Job	Truss	Truss Type	Qty	Ply	LOT 1 PROVIDENCE CREEK 81 PROVIDENCE CREEK DRIVE FUQUAY, VA
24-4510-R01	R02ARP1	Common	1	1	Job Reference (optional)

REPAIR(S) REQUIRED

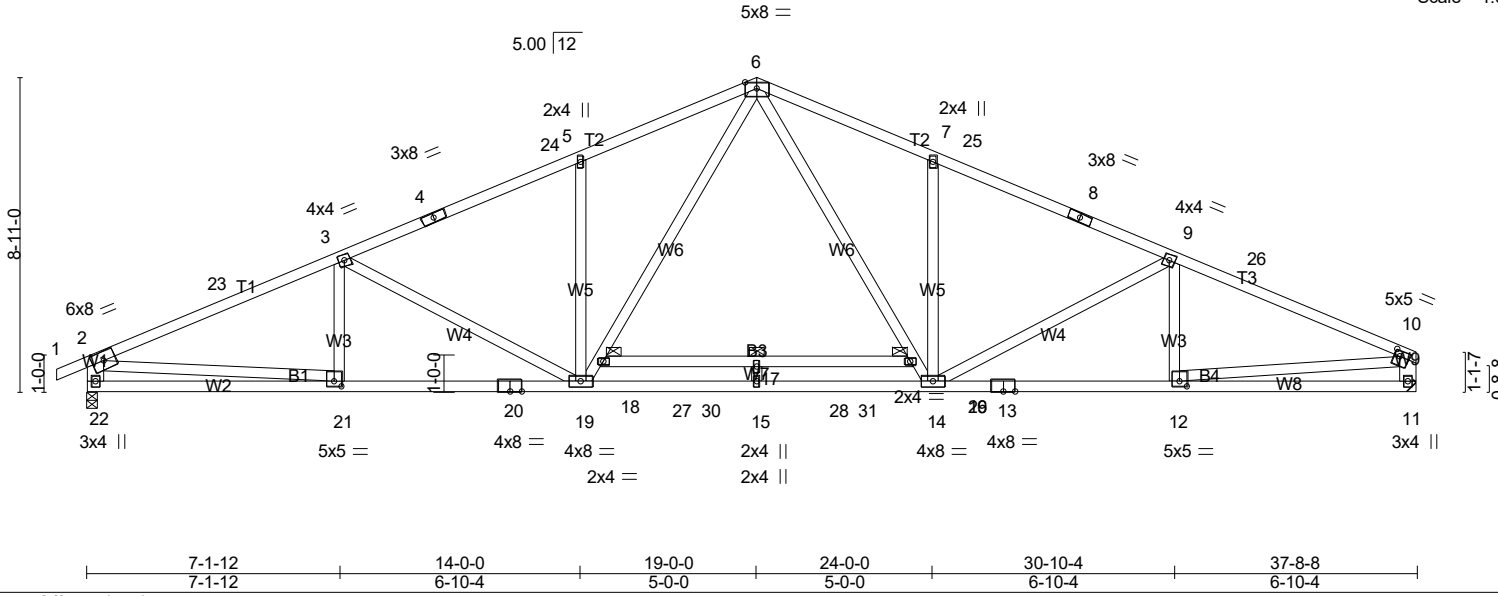
- 1) Repair Condition: Diagonal web 6-14 is broken 1-6-0 below joint 6.
- 2) Attach 45"H X 74"W X 3/4" Plywood or OSB (23/32" APA Rated Sheathing 48/24 Exposure 1) gusset to both sides of truss at joint 6 with 10d (0.131"x3") nails from each face, driven through both sheets of plywood. Connected together as follows: 2x4 - 2 rows 0-4-0 o.c. Minimum 0-3-0 end distance.
